File ref. no: BFS23/1695
Doc. ref. no: D23/57434
Contacts: Engineer Andy HUYNH
Senior Firefighter Nathan EVERETT

17 July 2023

Re: Cockle Bay Park Redevelopment – Blast and DG Assessment of Land Bridge & Supplemental DG Assessment of Landbridge Plank Design.

drawing
GA - Podium - Level 03, Crescent Garden - Level CG-03 /Landbridge

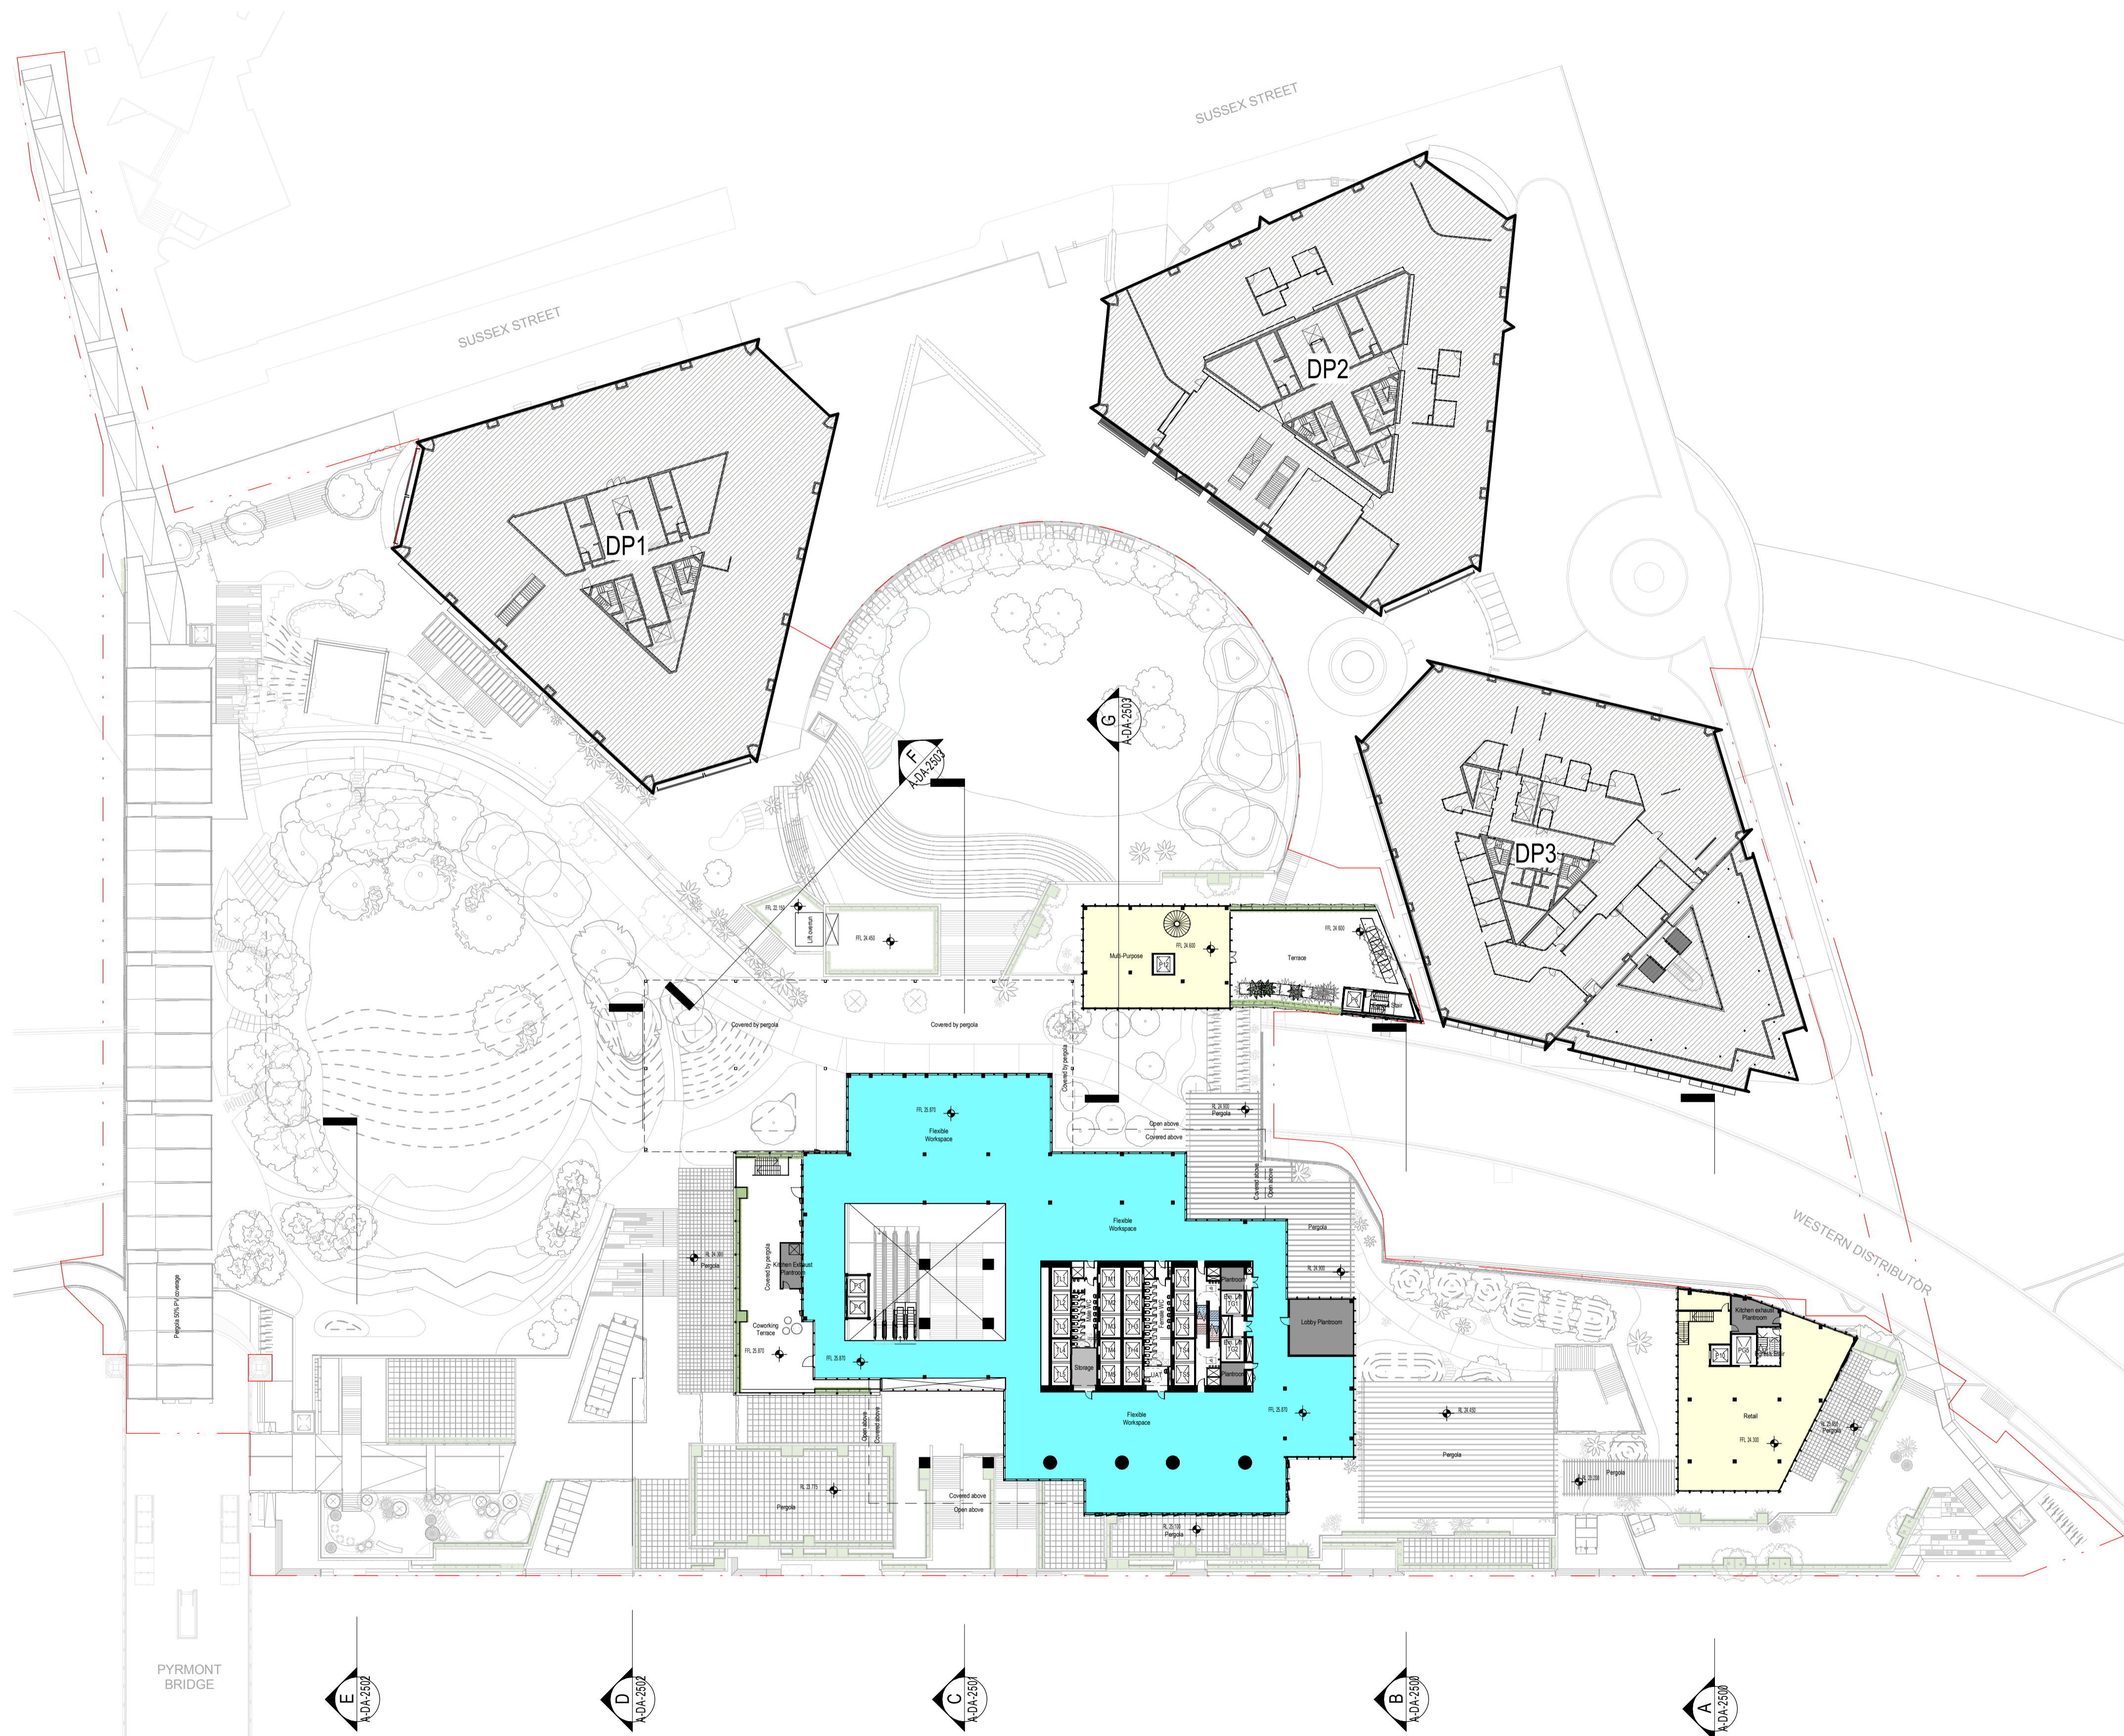
1. FRNSW provide in-principle support that the structure proposed to be constructed over the existing Western Distributor be defined as a 'land bridge', and that the space enclosed does not constitute a tunnel as defined within AS 4825-2011 *Tunnel fire safety*. This support is subject to justification being provided by way of a future detailed comparative and absolute assessment.

This in-principle support acknowledges that several design changes have been proposed since the original design submission in SSD-9978934 (FRNSW ref: D21/129156) such that the performance of the enclosed space exceeds that of a space that is not a tunnel, i.e., a substantially enclosed roadway that is less than 80 m in length. These design changes have been supported by preliminary comparative and absolute analysis.

4. FRNSW recommend that all structural elements be designed to withstand the effects of an incident involving dangerous goods such that occupants and attending emergency services are not put at risk of harm resulting from structural collapse.
